CITY OF PORTLAND BUILDING PERMIT

425 FORE ST

PERMIT ID: 2013-00038

RE: Fore Street Parking Garage – Stair Restoration

1ST LEVEL PLAN
 1/4"=1'-0"

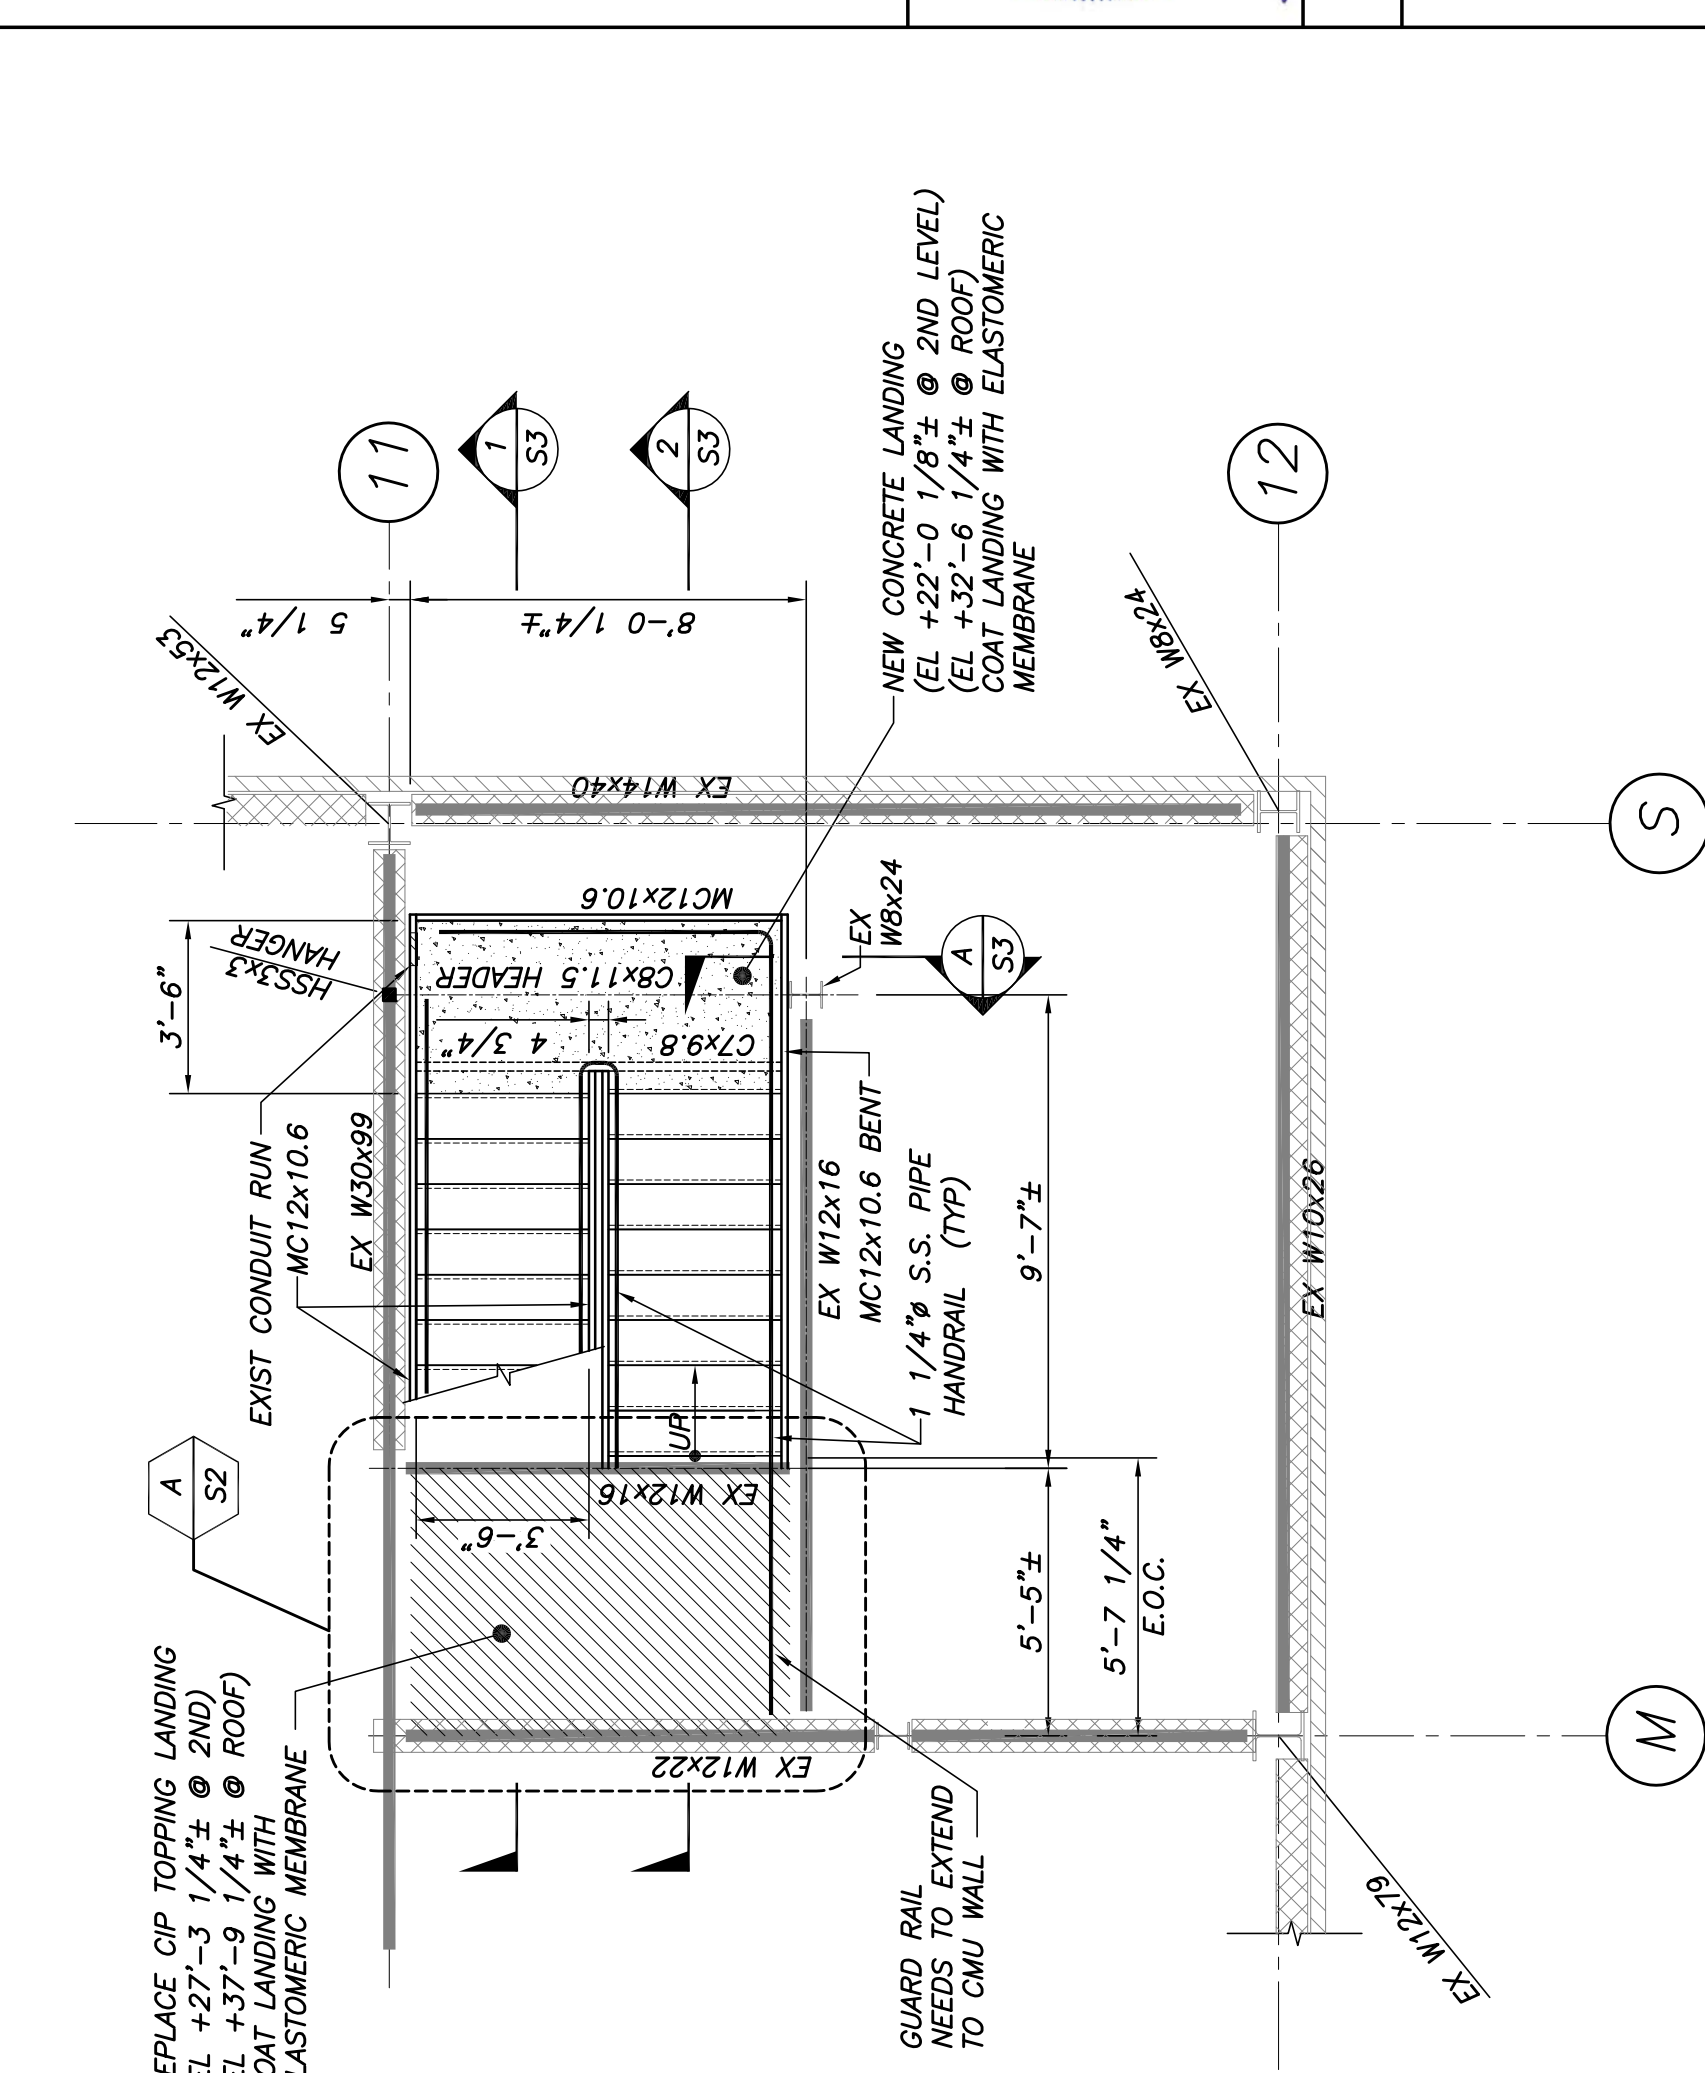
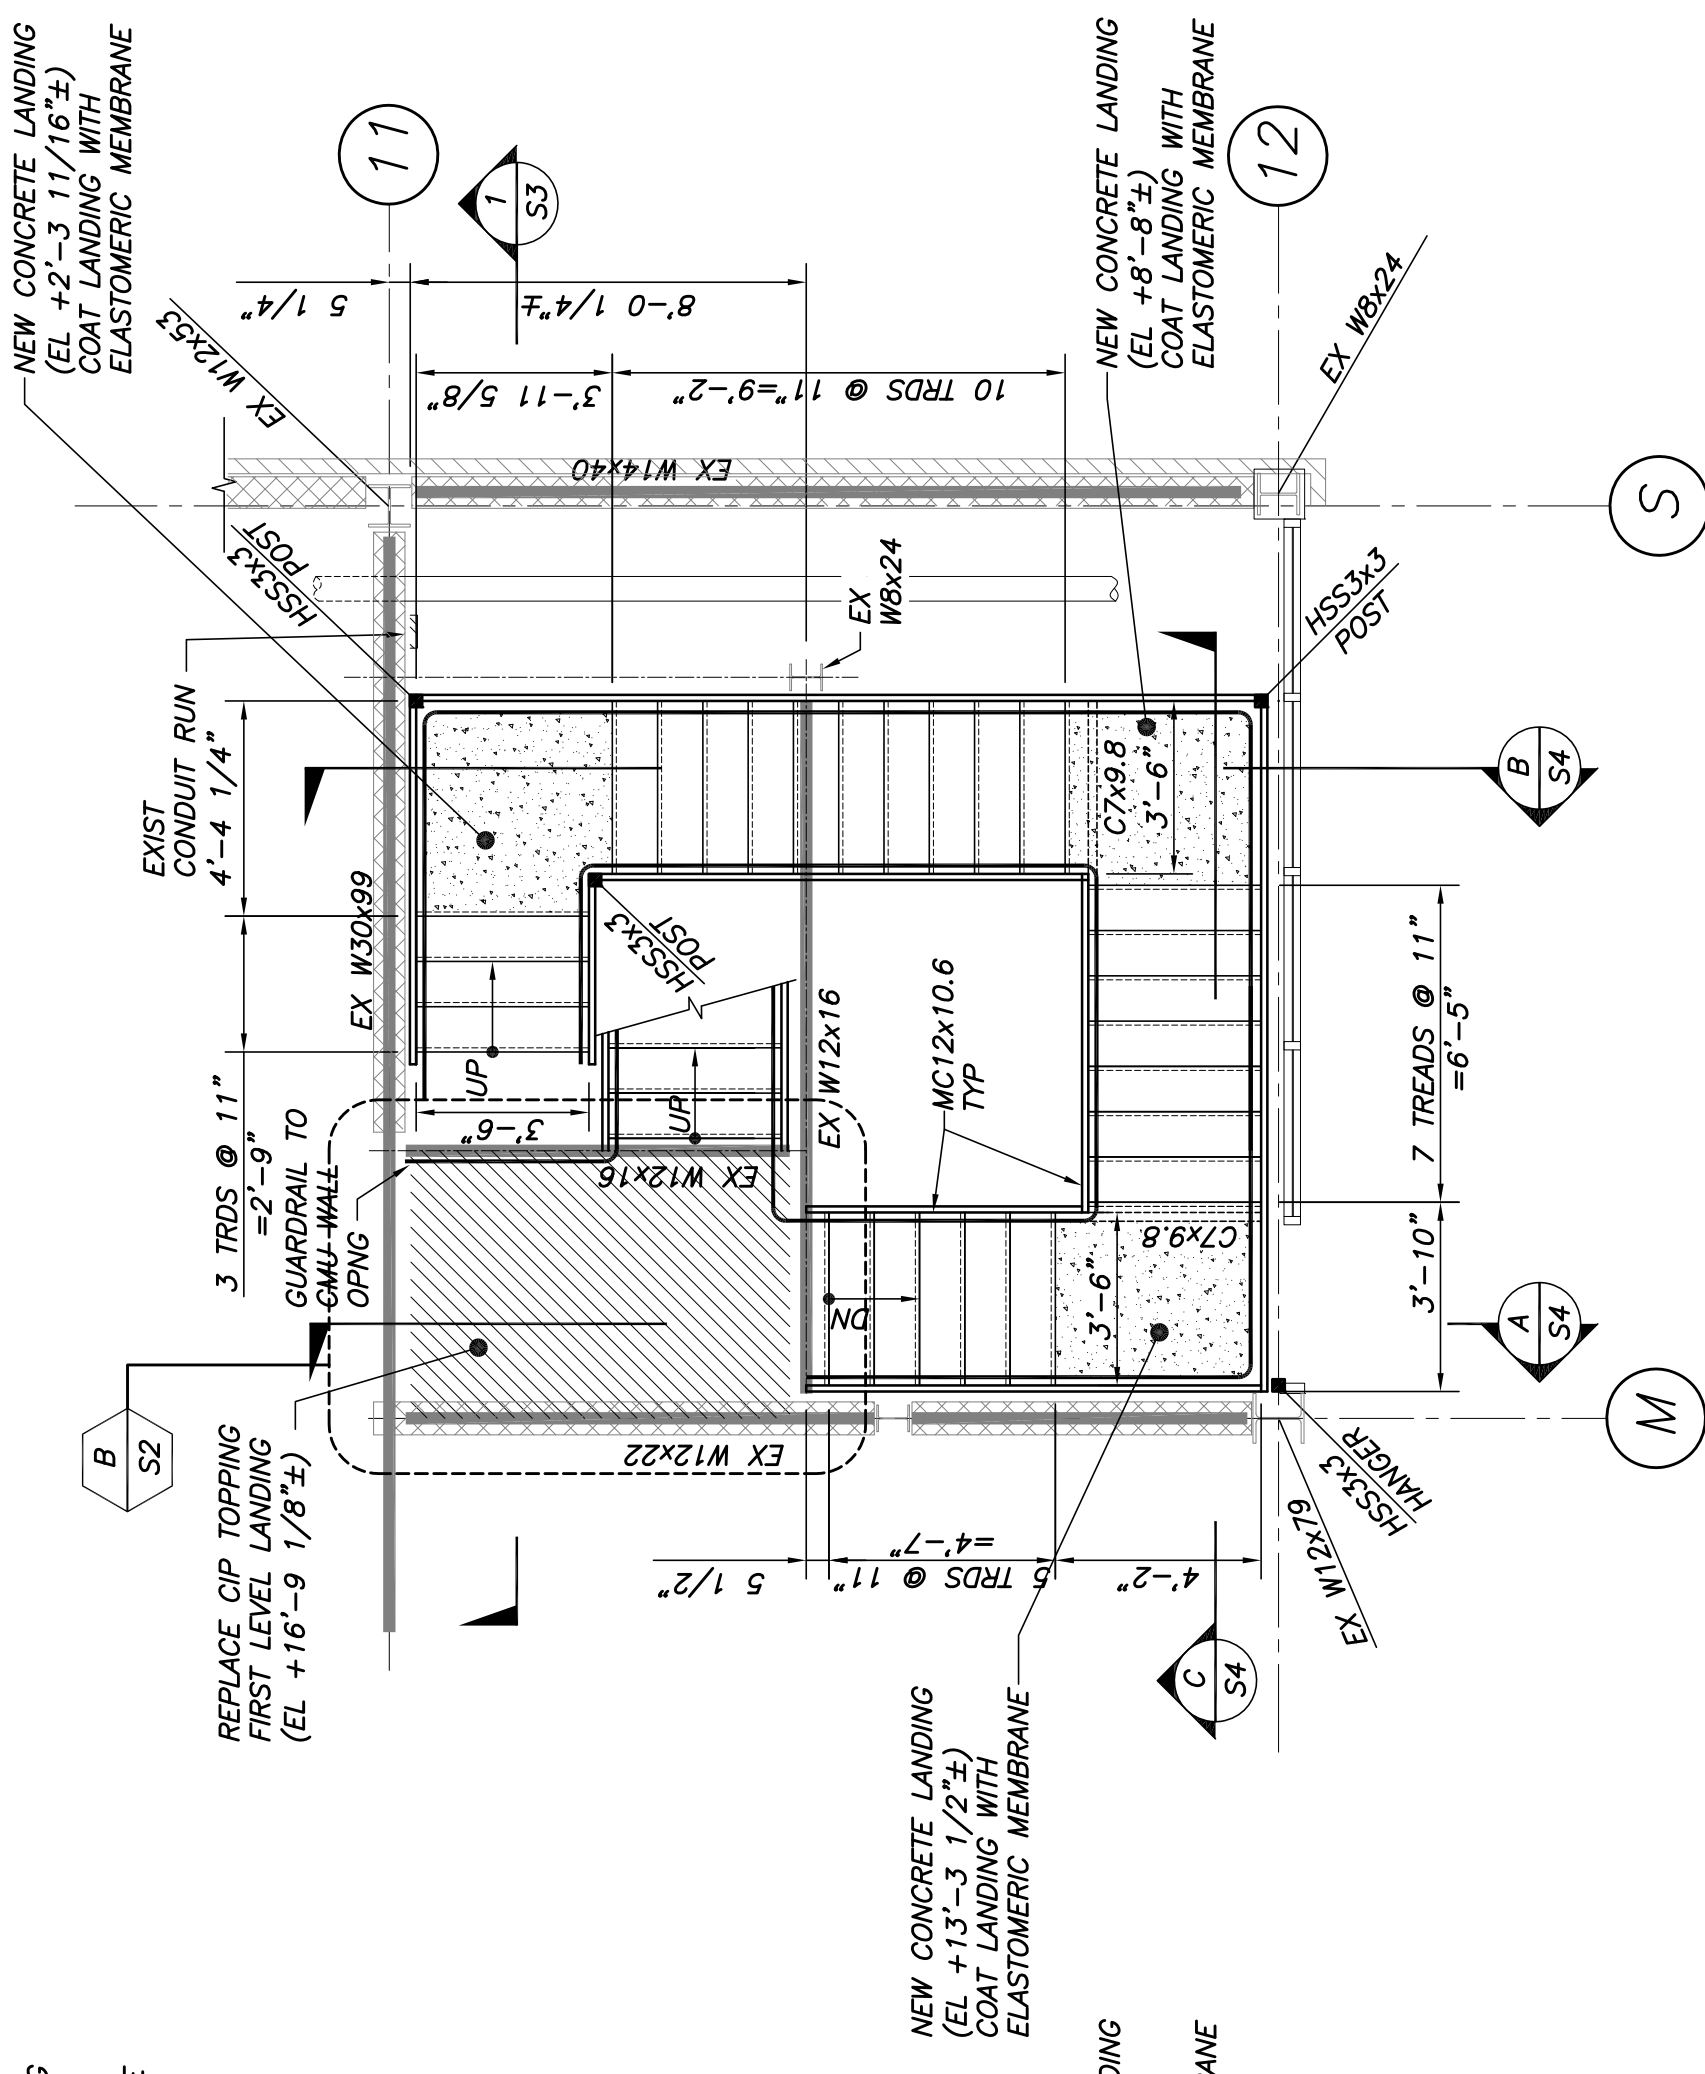
Andy also noted that you mentioned that the new stair width did not conform to the current code requirements. We are aware of this and in most of the stair we are limited by the existing opening between the beam on the 11 line and the existing W8x24 column between lines 11 and 12. We did maximize the tread width between these existing structural elements and were able to increase the width by 1" up to 3'-6". In addition we were able to create code compliant rise and run and did increase the width of the intermediate landings to help some of the potential congestion. It is my understanding of the International Existing Building Code that we are not required to meet all the requirement of the IBC for a stairway if the existing space and construction cannot accommodate those revisions.

Thank you for providing this information. Regarding the stair width, your clarification of the existing conditions prohibiting the increase in width to the required 44" is deemed acceptable per IBC Sec. 3404.1. The new stairs will provide a significant increase in public safety and compliance.

TEMPORARY EGRESS – TYPICAL FLOOR PLAN  
1/16"=1'-0"

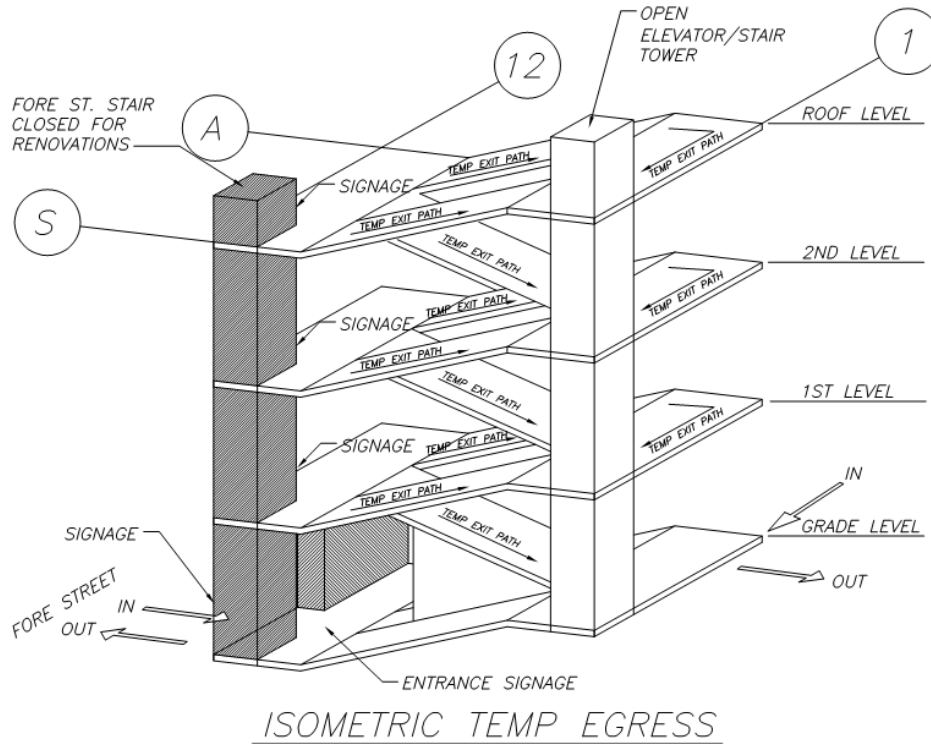
The contractor will provide a sign at the entrance of the garage indicating that the Fore St. Stair is closed for construction. In addition there will be signage at all levels to direct patrons to the nearest exit and indicate that the ramp system can be used as a secondary means of egress. The sketch below is a schematic representation of the signage plan proposed at each elevated level.
